Application for a non-material amendment following a grant of planning permission.

Number	
Suffix	
Property name	Merrydown
Address line 1	Kingston Lane
Address line 2	
Address line 3	
Town/city	East Preston
Postcode	BN16 1RP
Description of site location must be completed if postcode is not known:	
Easting (x)	507751
Northing (y)	102607
Description

Increase the height of the proposed structure by 300mm over that approved and increase the depth of the structure by 500mm, retaining distance from high and neighbours boundary as per the original proposal.
Replace barn style doors with Roller garage door to enhance security and accommodate traditional oak knee bracing.

West Elevation 1:50

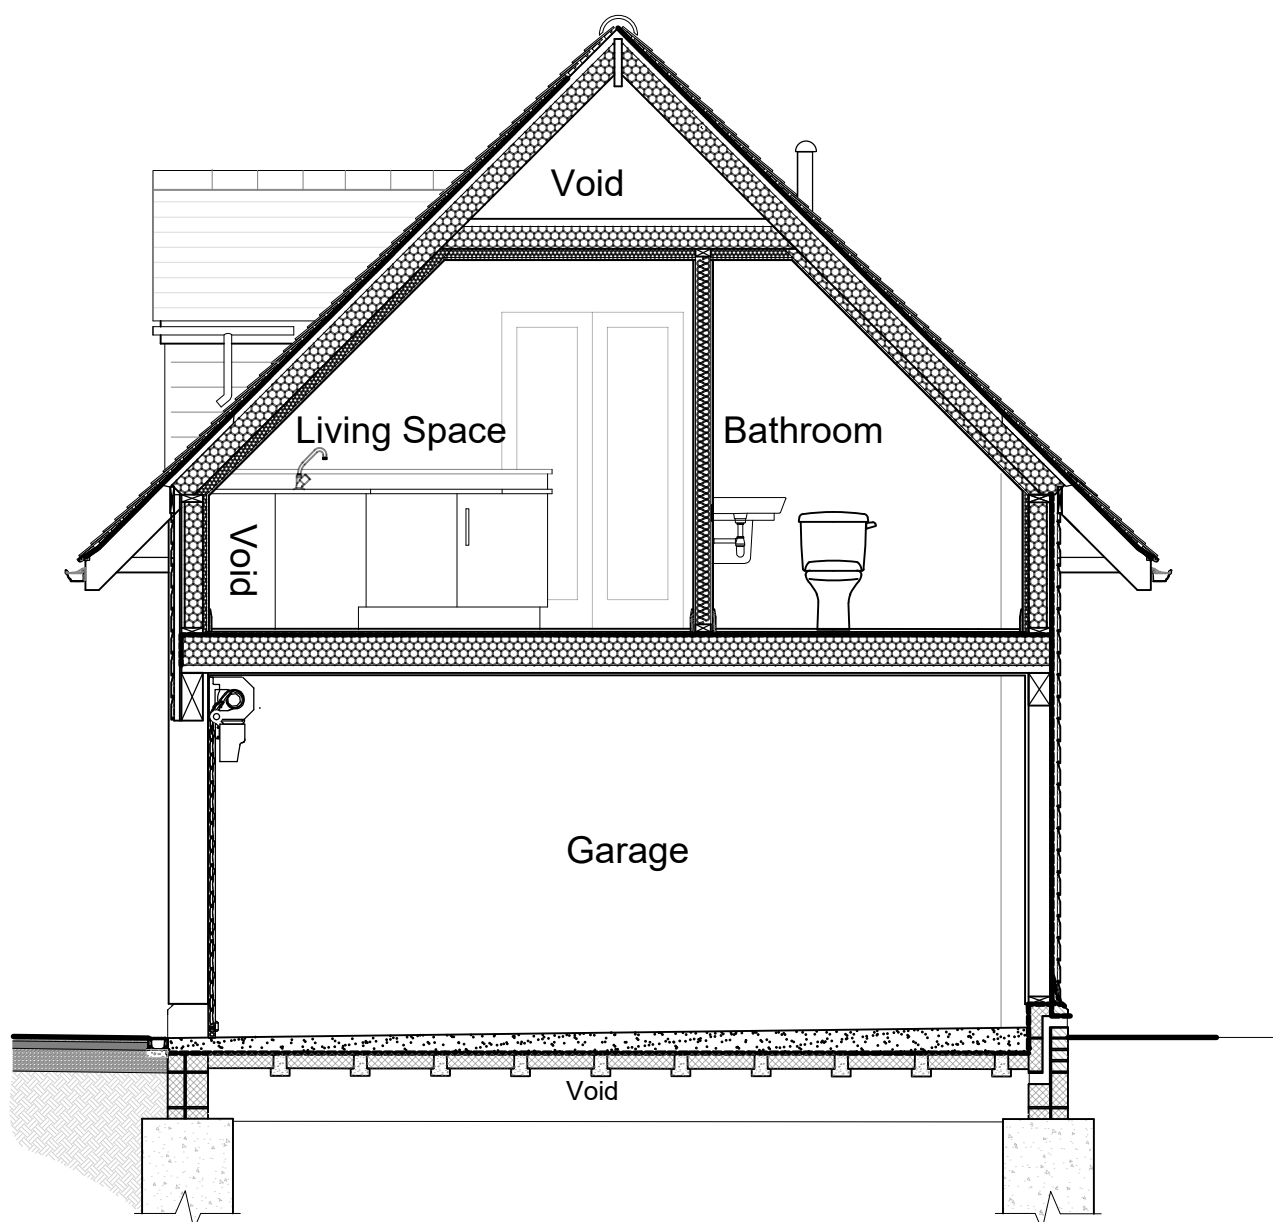
To accommodate a revised roof structure, which will more more cost effective, and to improve the garage depth taking into account an internal framed roller garage door (which will improve security).
